RE: **HOLIDAY BREEZE SUBDIVISION (F-22/D36)**
Engineers Certification- (additional detail sheets submitted)
Engineers Stamp dated 10/29/1998, Rev. 1/25/1999, 4/21/1999, 6/26/2002
Engineers Certification dated 3/21/2002

Based upon the information provided in your Engineers Certification dated 3/21/2002, and the subsequent sheets submitted 6/26/2002 providing details of the drainage structure at the end of the new cul-de-sac, and the removal of the proposed bollards and insertion of the new retaining wall, the above referenced plan is adequate to satisfy the Grading and Drainage Certification for the above referenced project.

RE: **HOLIDAY BREEZE SUBDIVISION (F-22/D36)**
Engineers Certification For Release of Financial Guaranty
Engineers Stamp dated 10/29/1998, Rev. 1/25/1999, Rev. 4/21/1999
Engineers Certification dated 3/21/2002

**Re: Holiday Breeze Subdivision Amended Grading Plan
Engineer's Stamp dated 4-20-01 (F22/D36)**

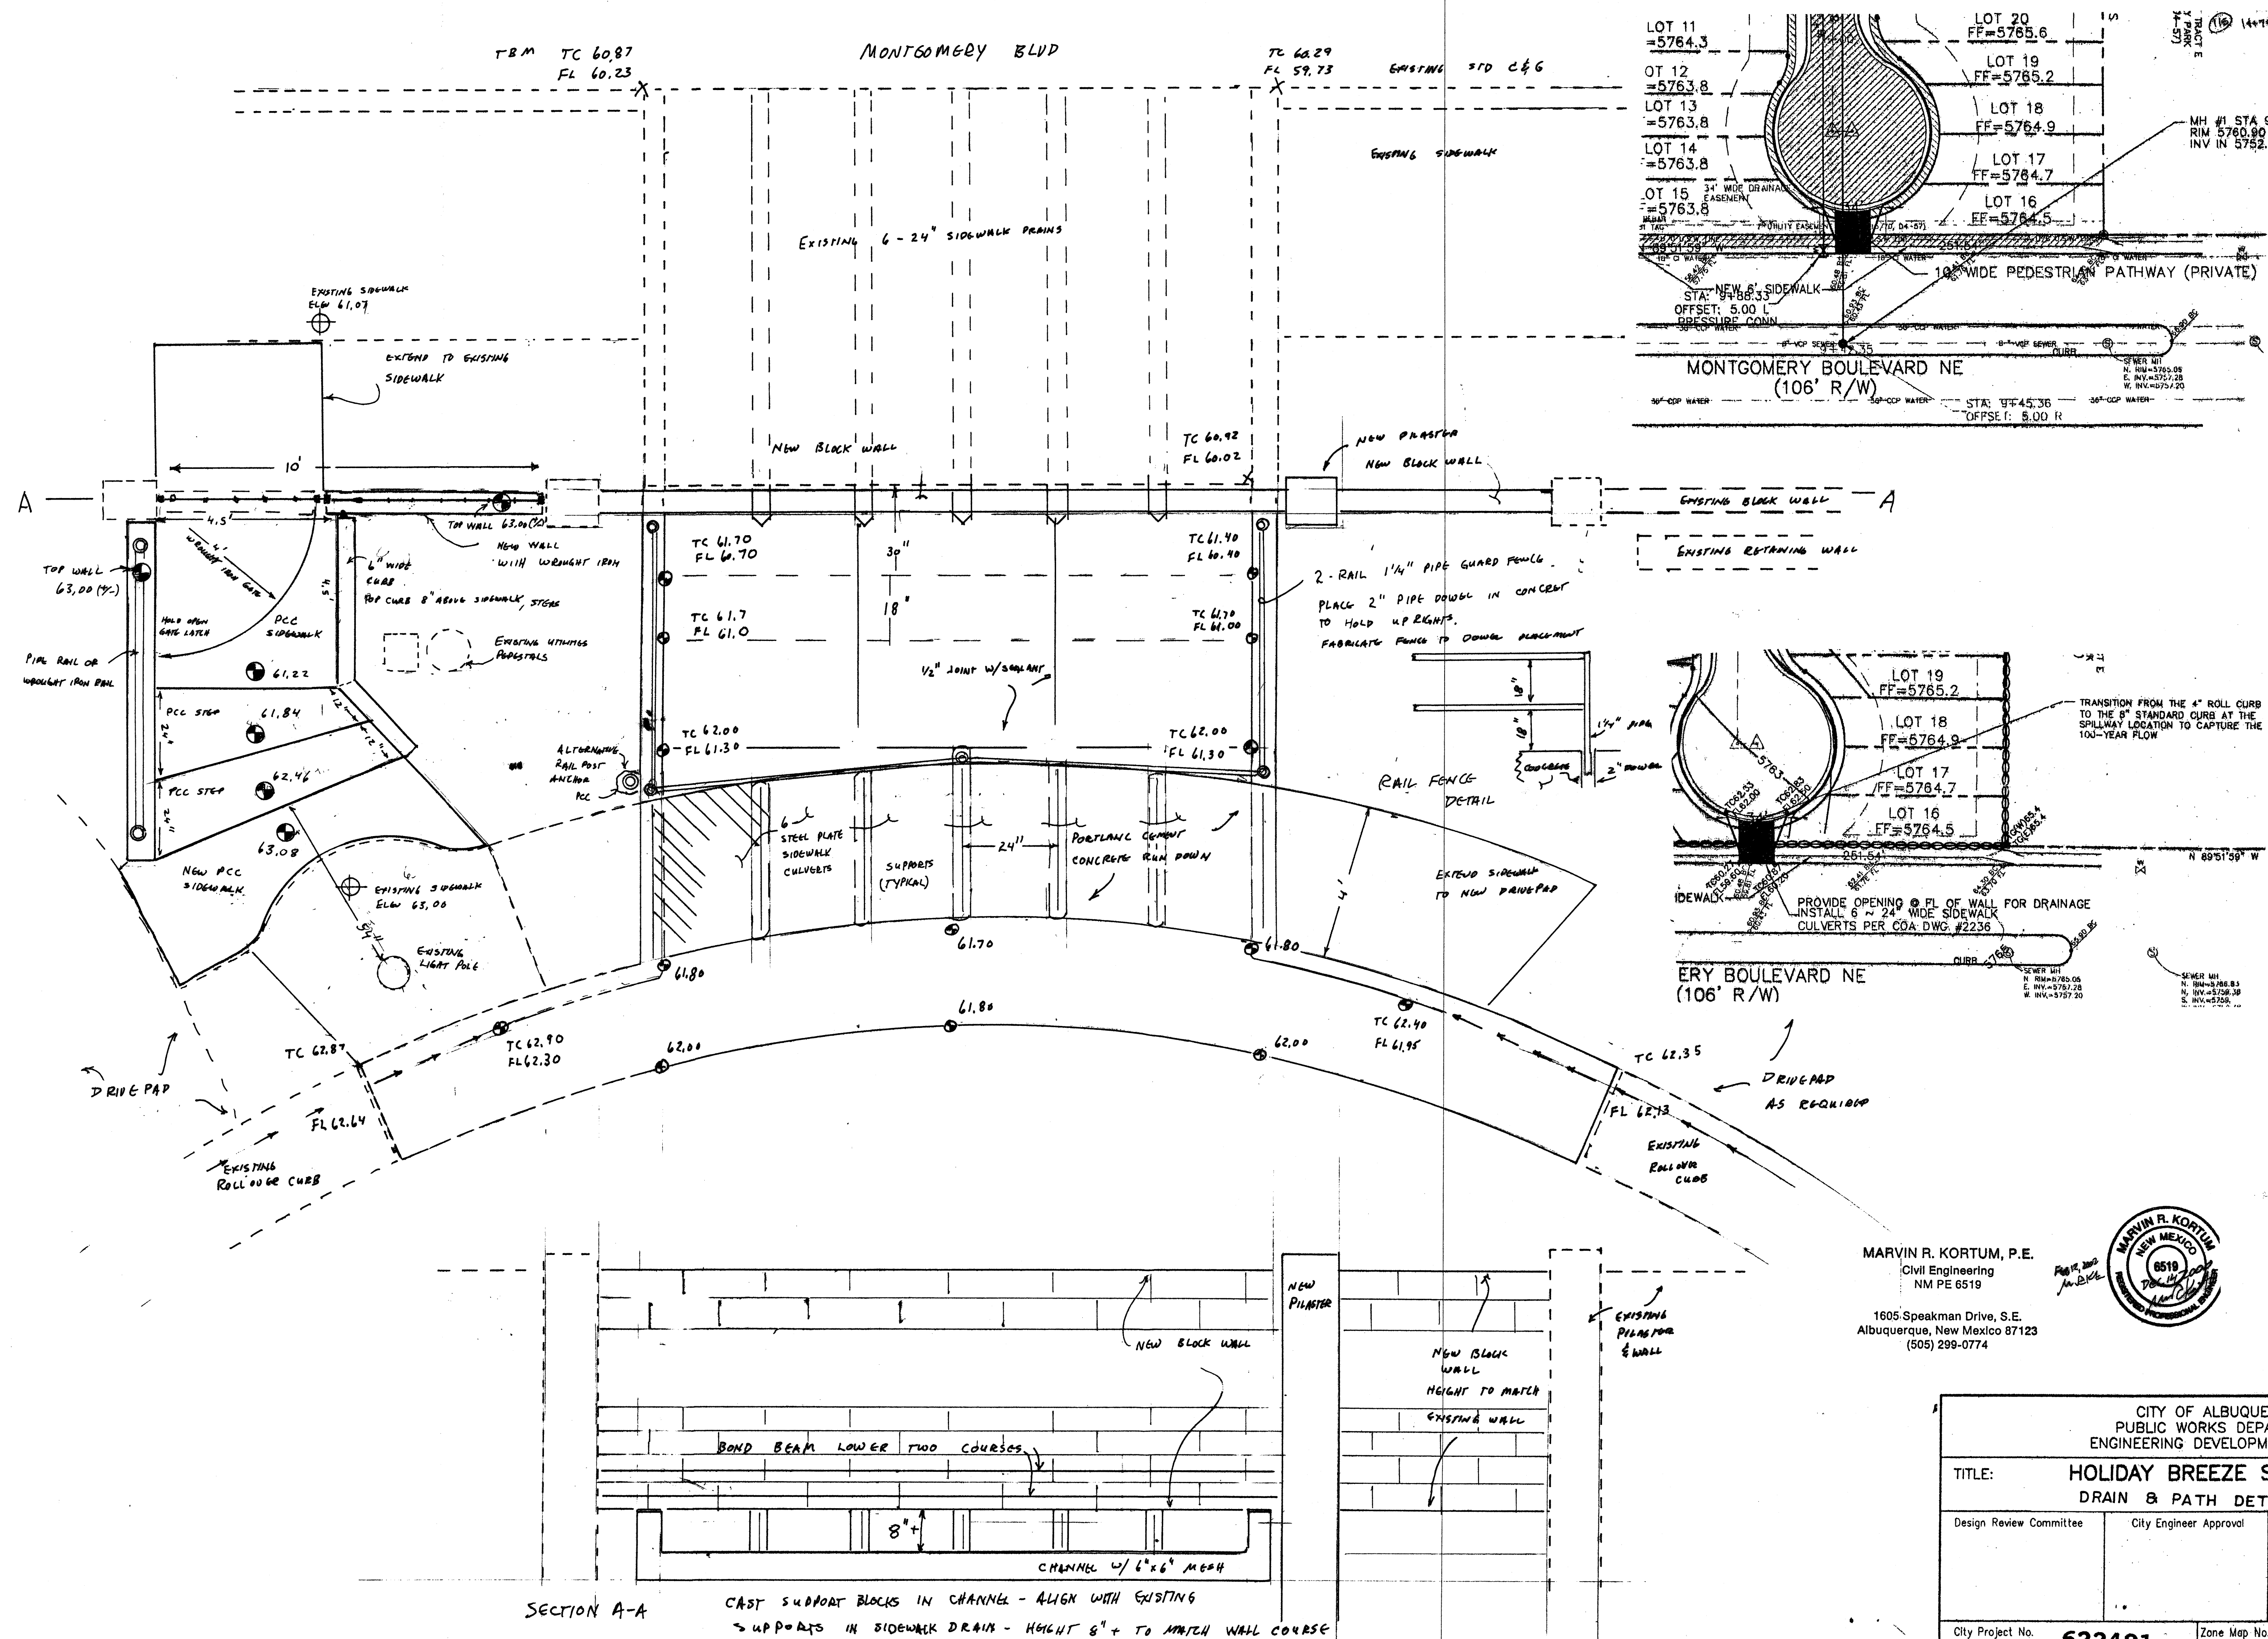
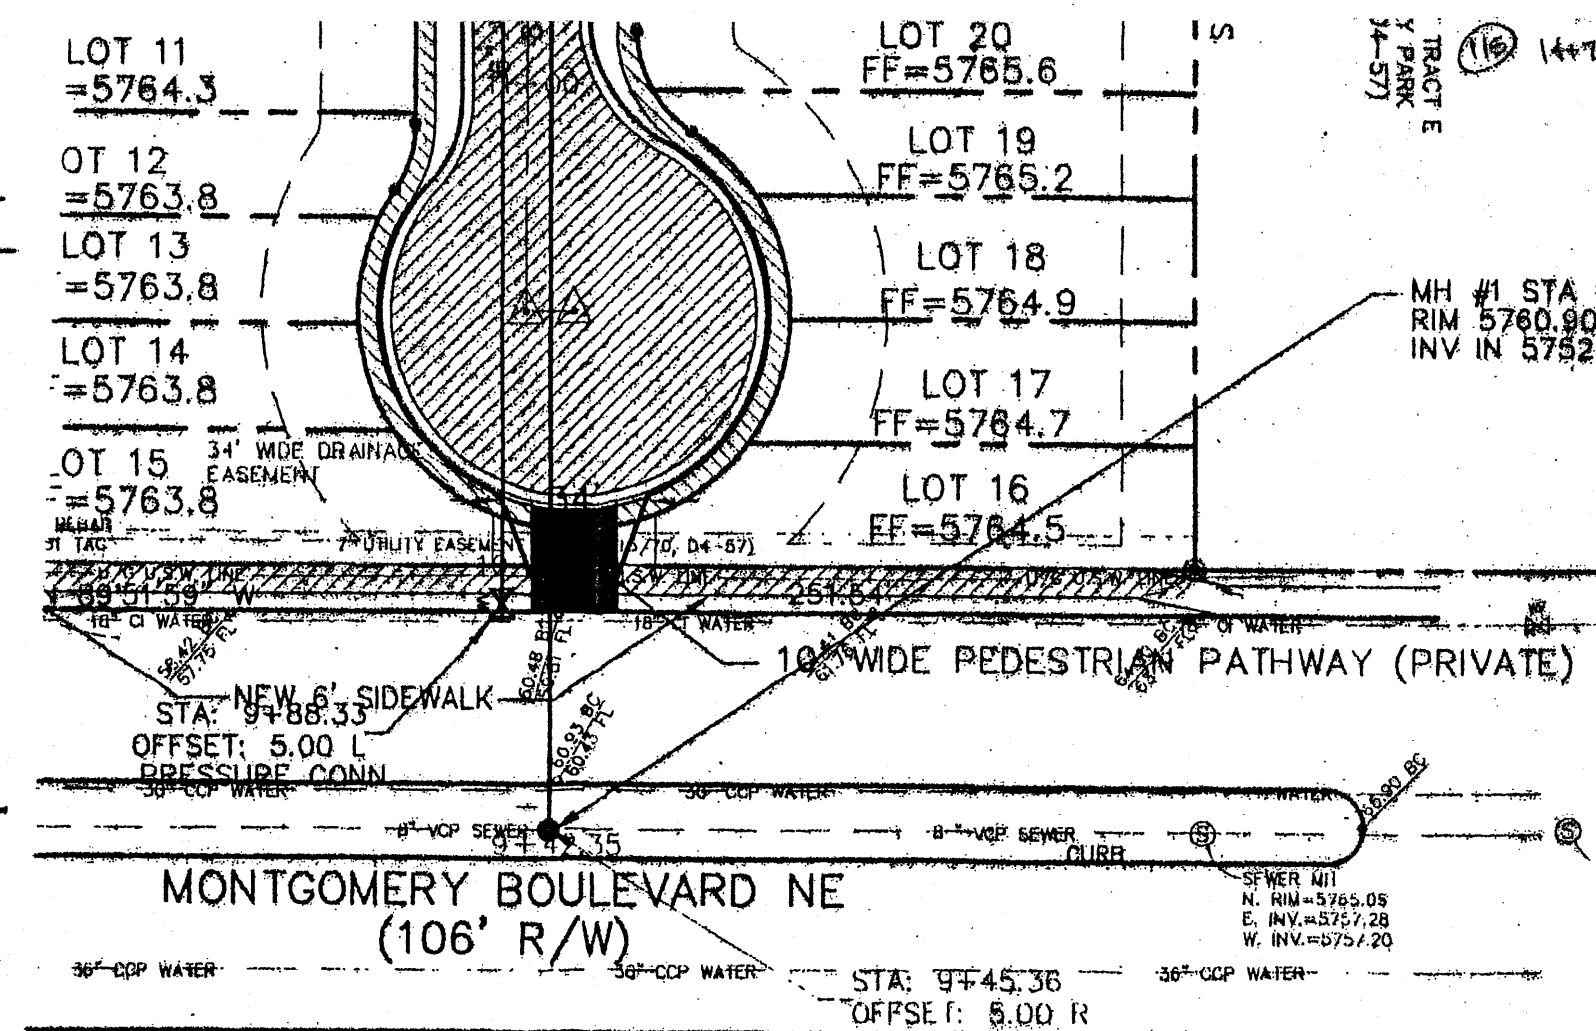
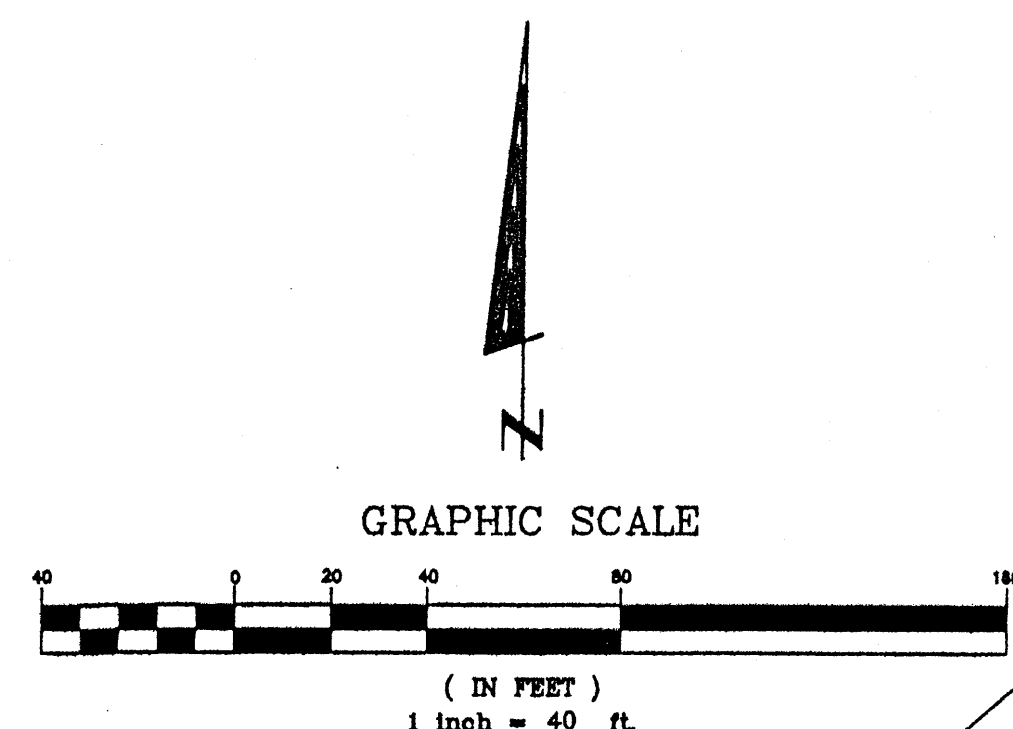
A. The original drawings as approved by the City of Albuquerque showed a black square at the south end of the street, adjacent to Montgomery Boulevard, with a notation;

1. "Provide opening at FL of wall for drainage. Install 6-24" wide sidewalk culverts per COA DWG #2236."

At the request of the city inspector, detailed drawings were prepared to show the drainage structure from the end of the new cul-de-sac to the sidewalk culverts installed on Montgomery Boulevard. These details, which were not shown on the original work order drawings, are shown on the attached drawing, proposed sheet 9 of 9. Construction Management requests specific approval of the drainage structure, including the pipe rail, and the setting of the pipe rail in separate concrete postholes.
